CITY OF ALBUQUERQUE

RE: **Rohan Subdivision**
Lots 3 – 4
Requested for Pad Cert – Not Accepted
Engineers Stamp Date 6/29/15 (C19D042A)
Certification dated: 3-6-19

Based on the certification provided in your submittal received 3/7/2019, the above referenced site cannot be accepted for release of Pad Certification by Hydrology until the following comments are addressed:

**LOTS 1 THRU 4, ROHAN SUBDIVISION
GRADING AND DRAINAGE PLAN**

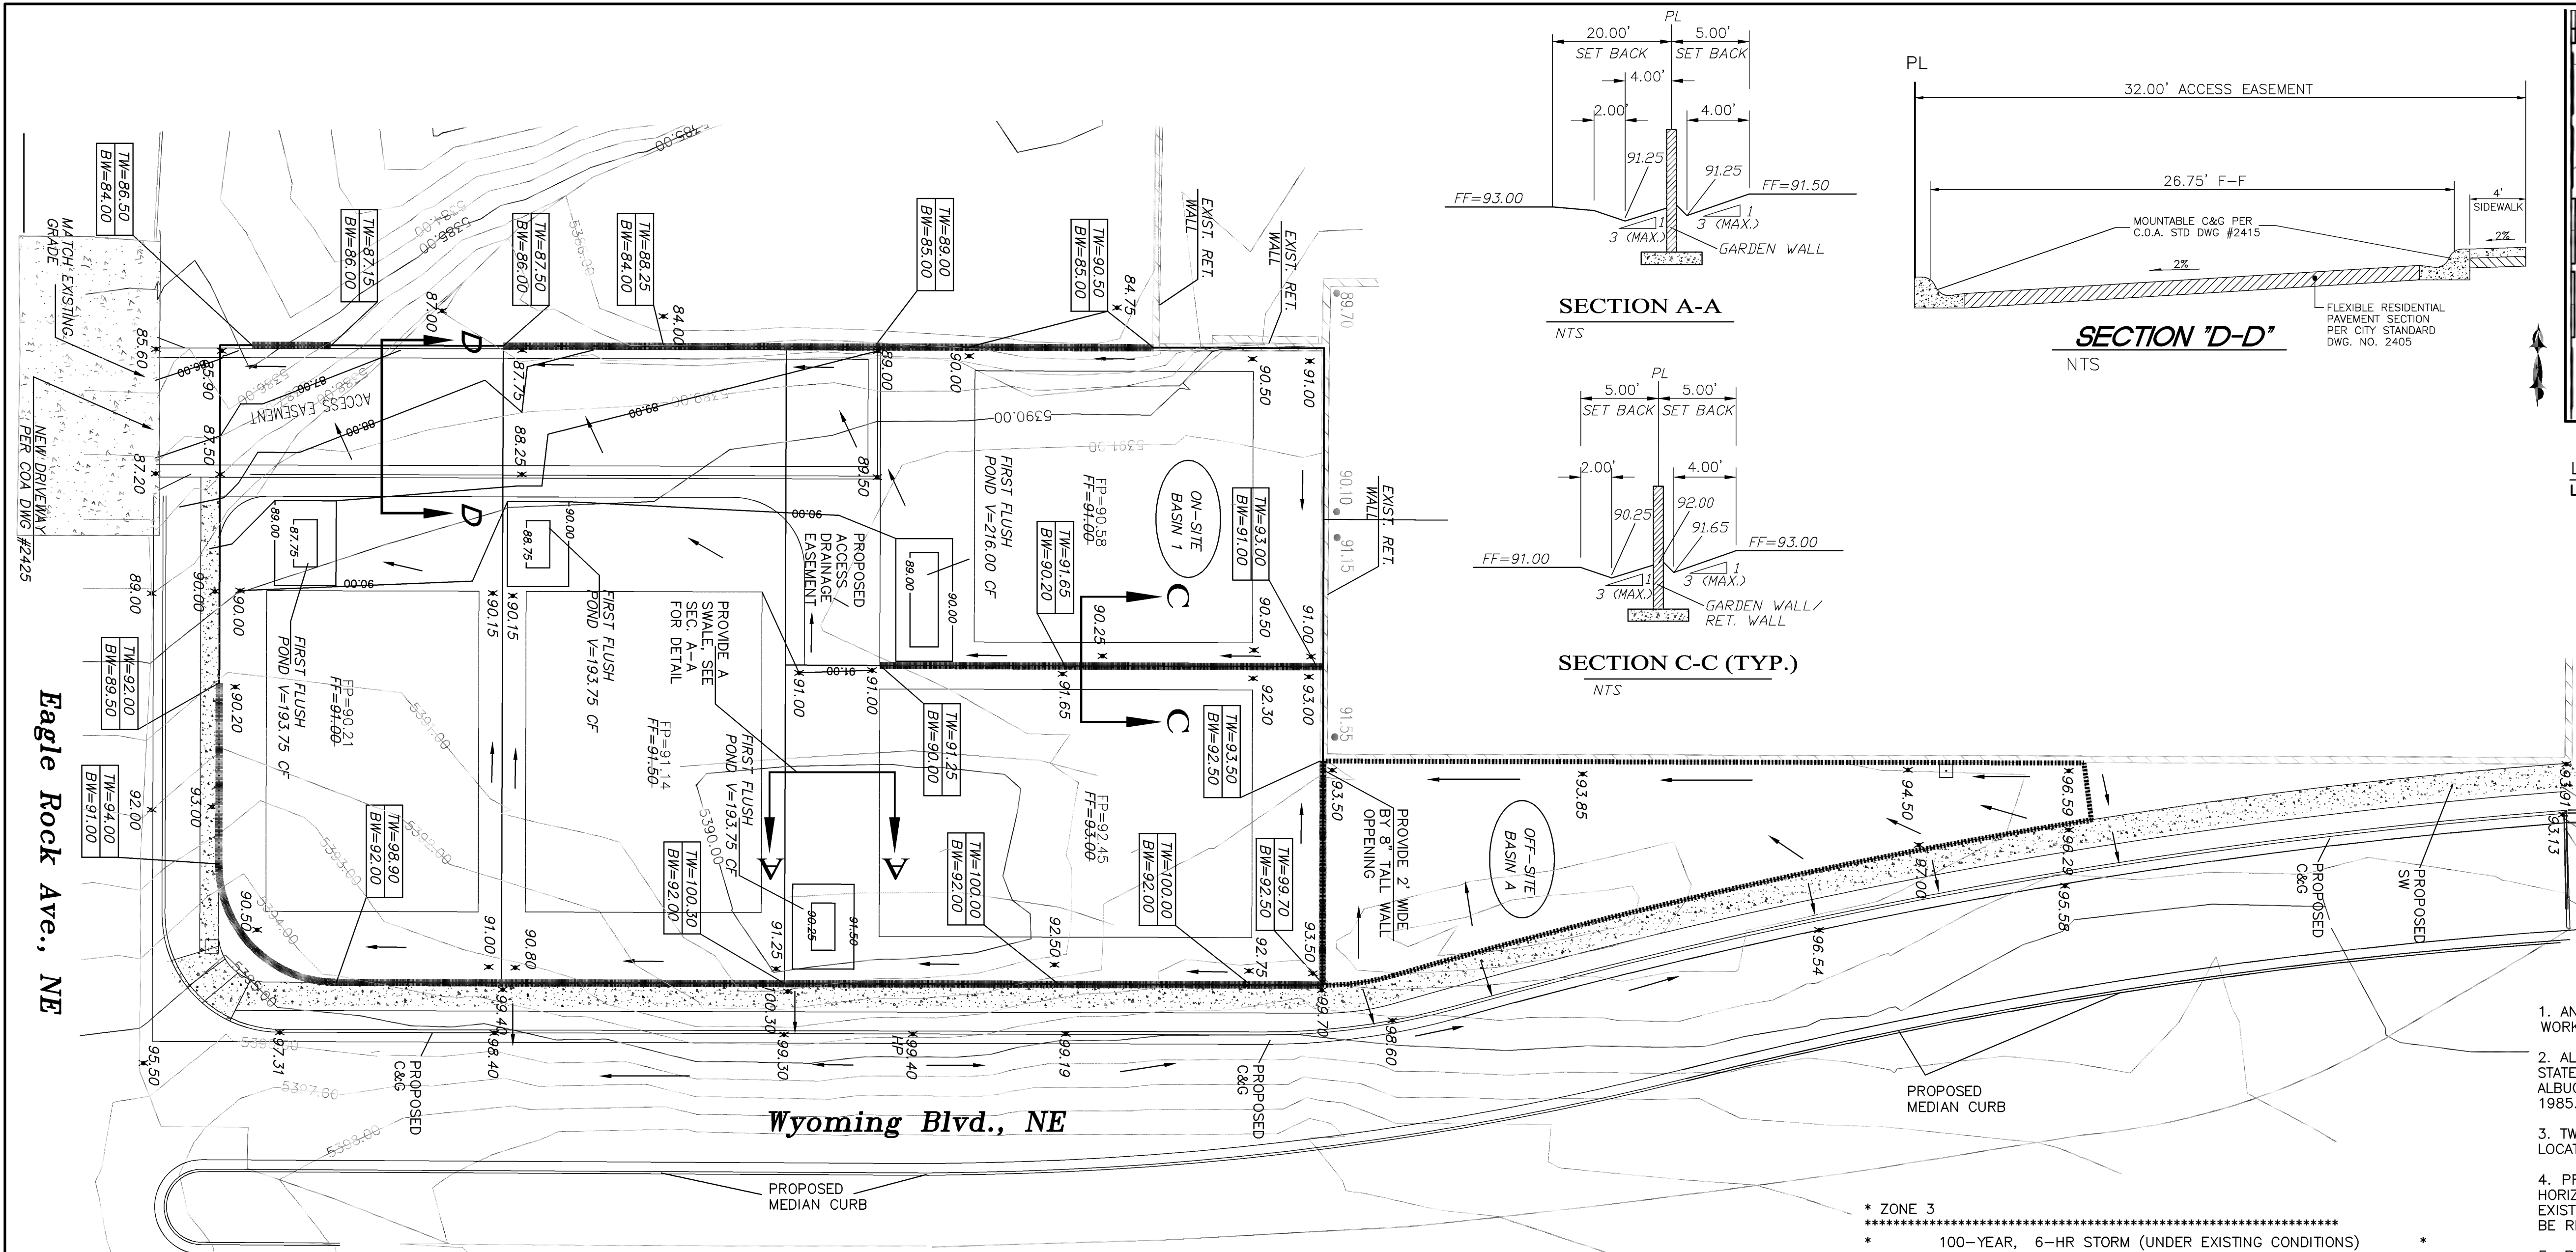
- Wall opening lot 3 is different than on plan. Clarify in certification that smaller opening is sufficient.
- Swales on both sides of garden wall (section A-A) between lots 2 and 3 are missing.
- Ponds are missing on lot 3 and 4.
- Provide request for Release of Financial Guarantee
